## 94 Pine St - permit BLDR2018-00409

**Christina Stacey** <cstacey@portlandmaine.gov>  
To: slebel@acorn-engineering.com

Plan Depicting The Results Of A Boundary Survey
Made For
Thomas & Judith Watson
Southeasterly Sideline Of Pine Street & Easterly Sideline Of Emery Street
Portland, Maine

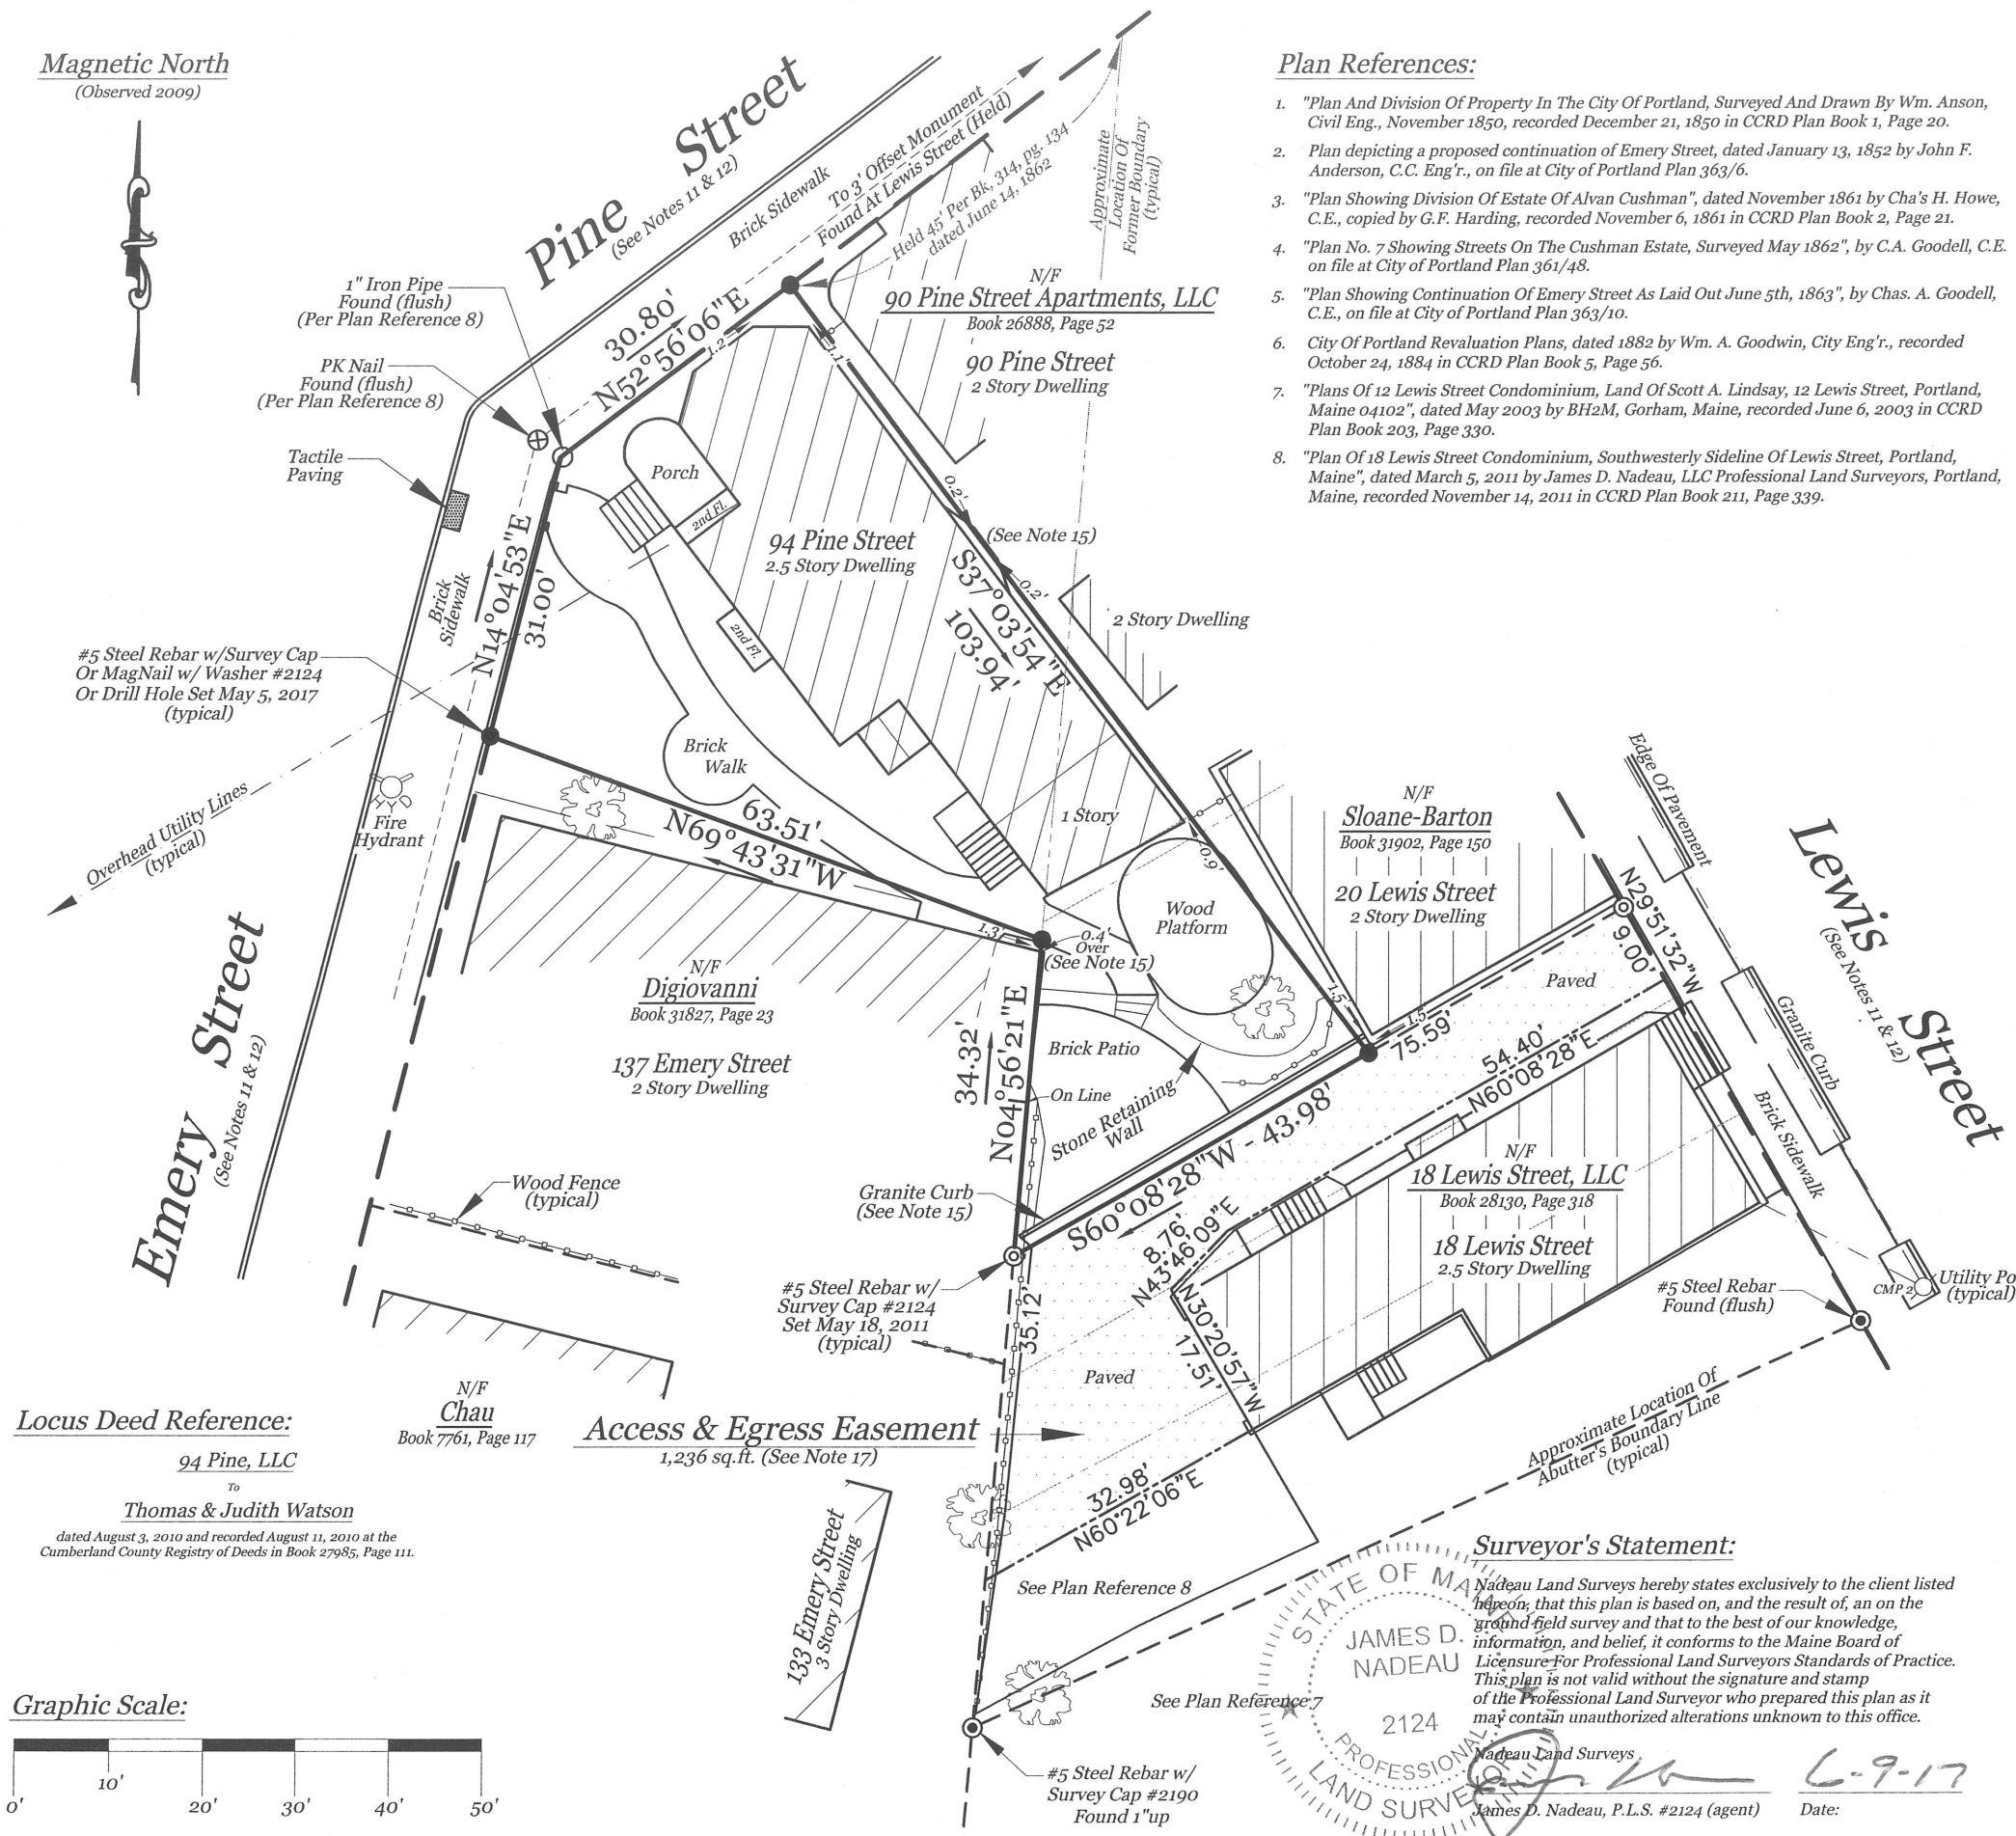
I was looking at the above project for zoning compliance and had a question about one requirement. In this zone, at least 20% of the lot must be maintained as "landscaped open space" - green area such as garden beds, lawn, tree/shrub, etc. The survey indicates the lot area is 3,795 square feet, which means that at least 759 square feet of the lot must be green space. It appears that some green space in the back may be impacted by the parking and patio expansion. I tried to do a rough scale off the survey of what the final area of landscaped open space might be, and I scaled approximately 743 square feet. But it is difficult to get a completely accurate number based on the information I have at hand. Would you please provide me more detailed information on what the final landscaped open space area will be, so we can confirm that it is meeting the 759 sq ft minimum?

Please see attached the green space pulled from the survey which will not be impacted by the site work. The total is 877 sf.
